CITY OF ALBUQUERQUE

**Re: Hillside Auto
134 Tennessee NE
Request for Certificate of Occupancy- Transportation Development**
Engineer's/Architect's Stamp dated 1-22-16 (K19-D148)
Certification dated 1-21-16

Based upon the information provided in your submittal received 1-25-16, Transportation Development cannot issue Certificate of Occupancy for the above referenced project.

TRAFFIC CIRCULATION LAYOUT

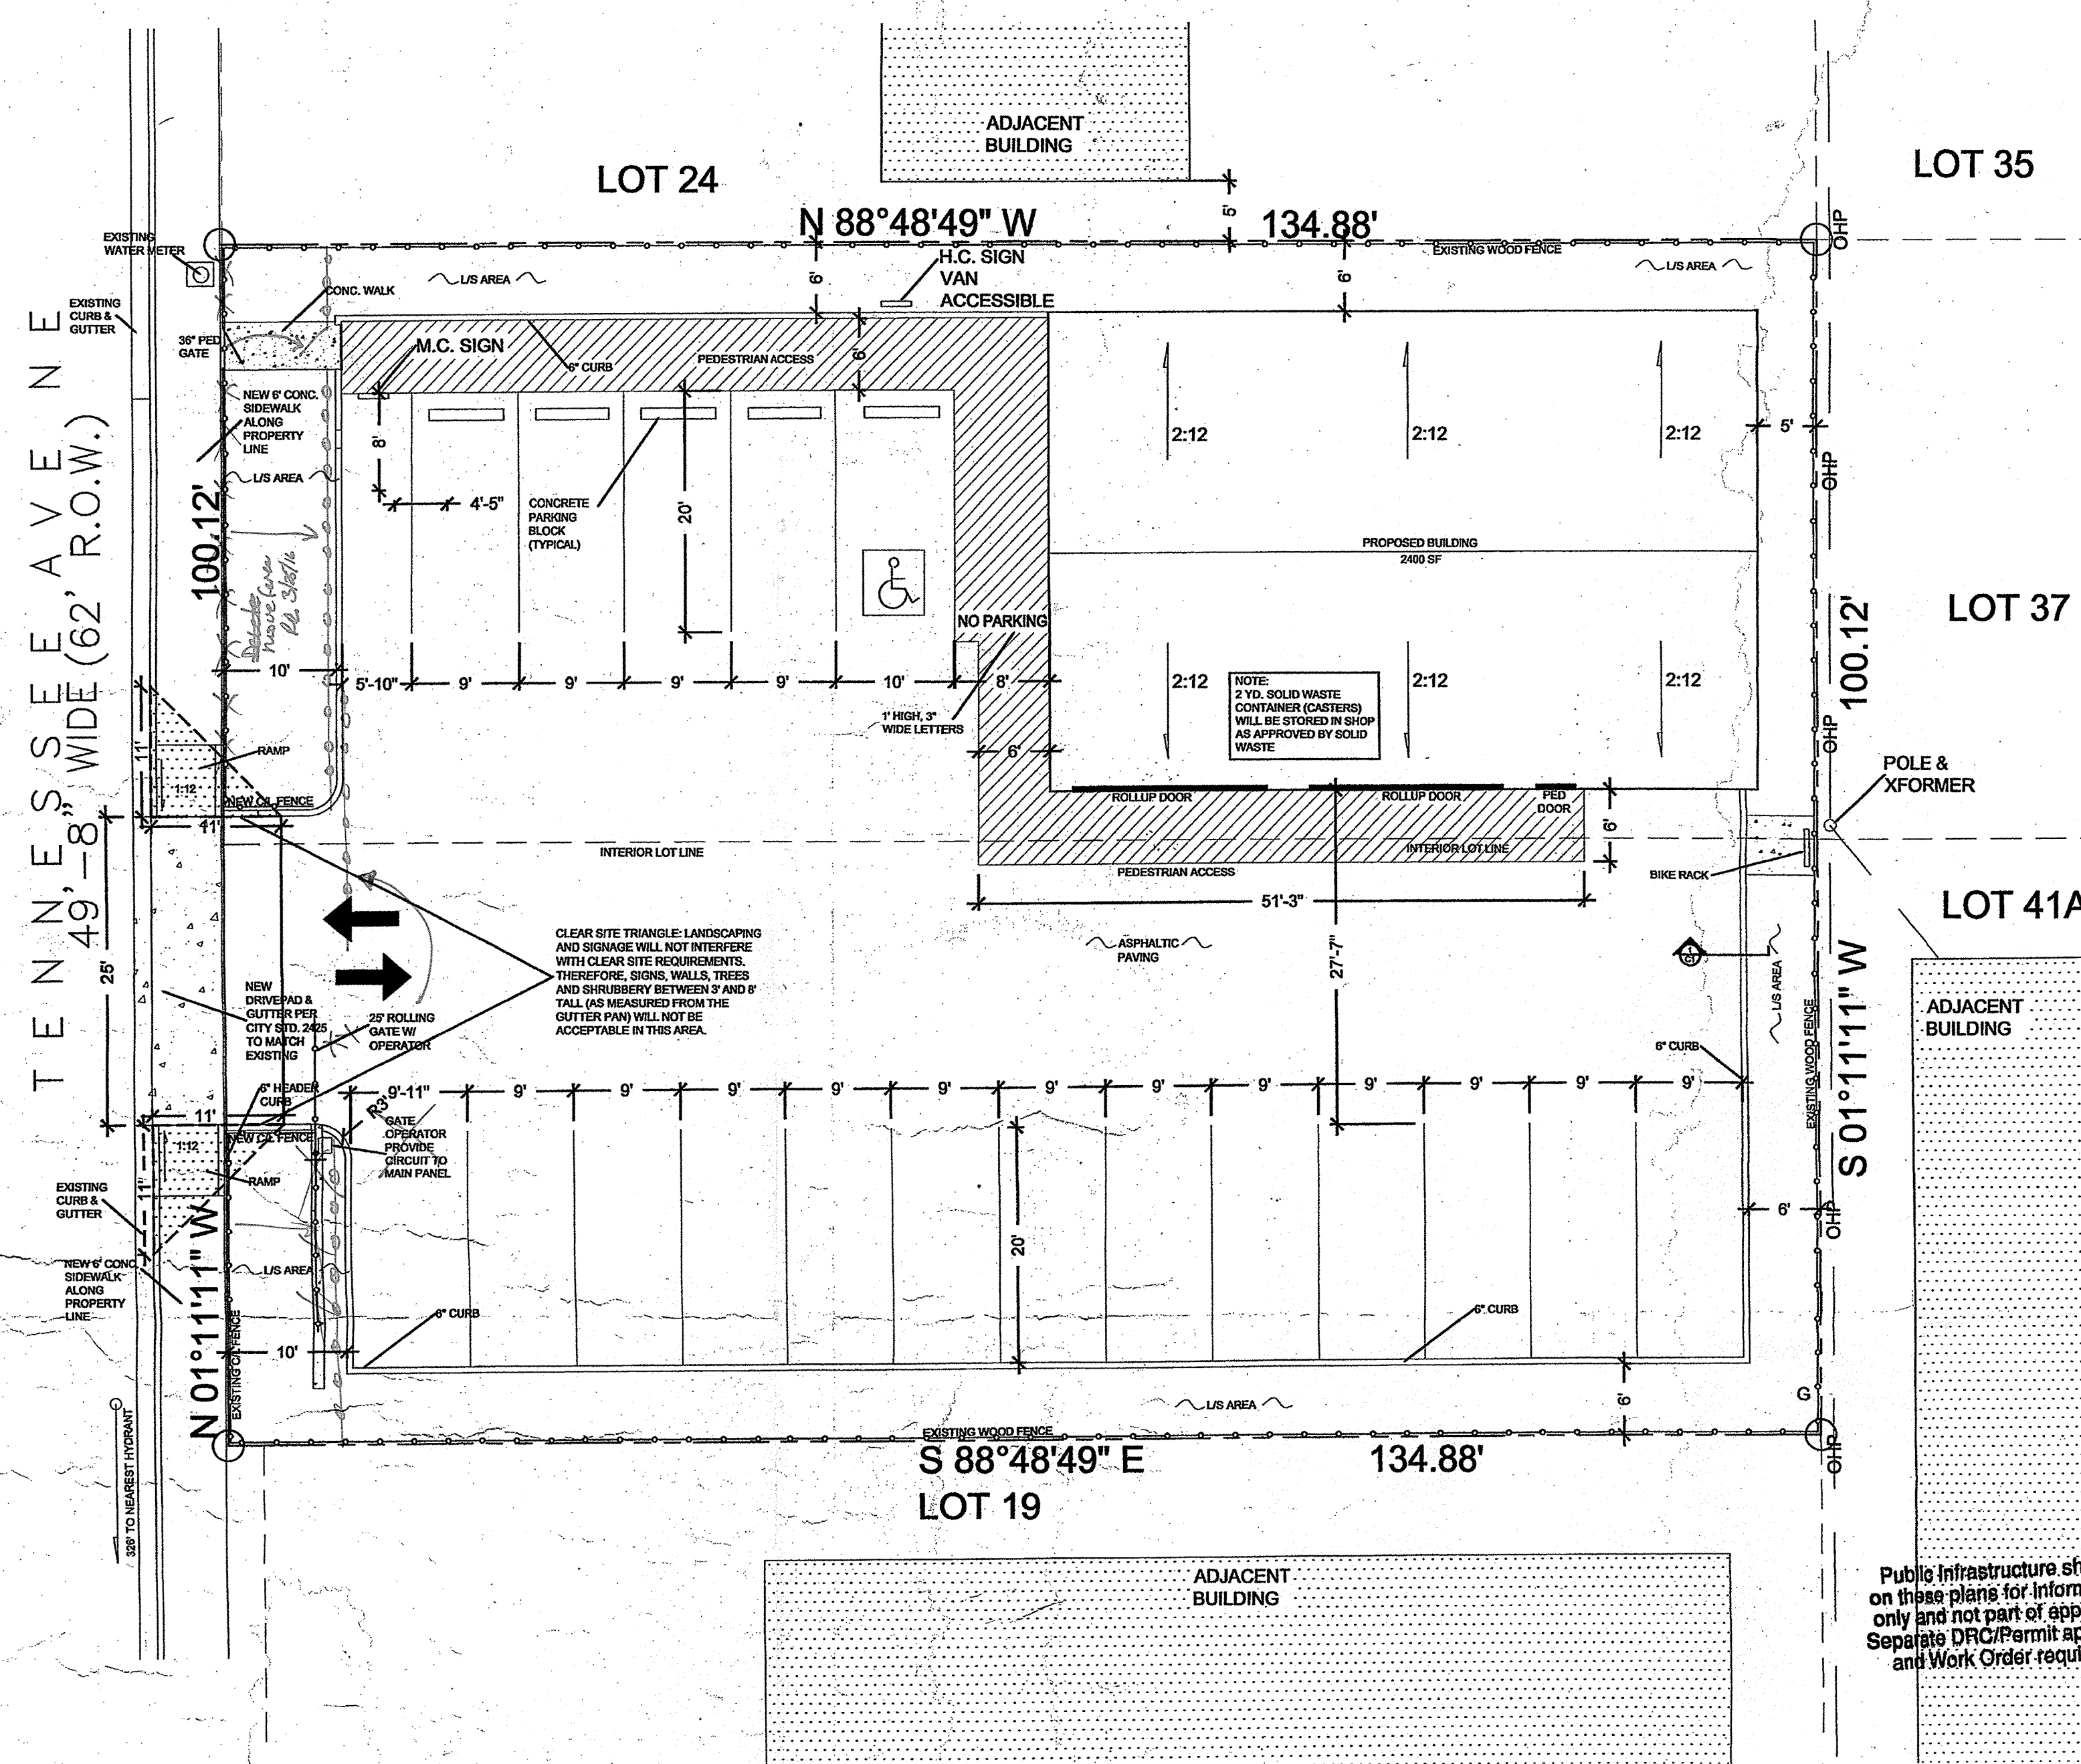
- Completion of parking lot striping and installation of ADA signs.
- Project site must be available for on-site inspection.
- Please submit the TCL Approved drawing when project is completed.
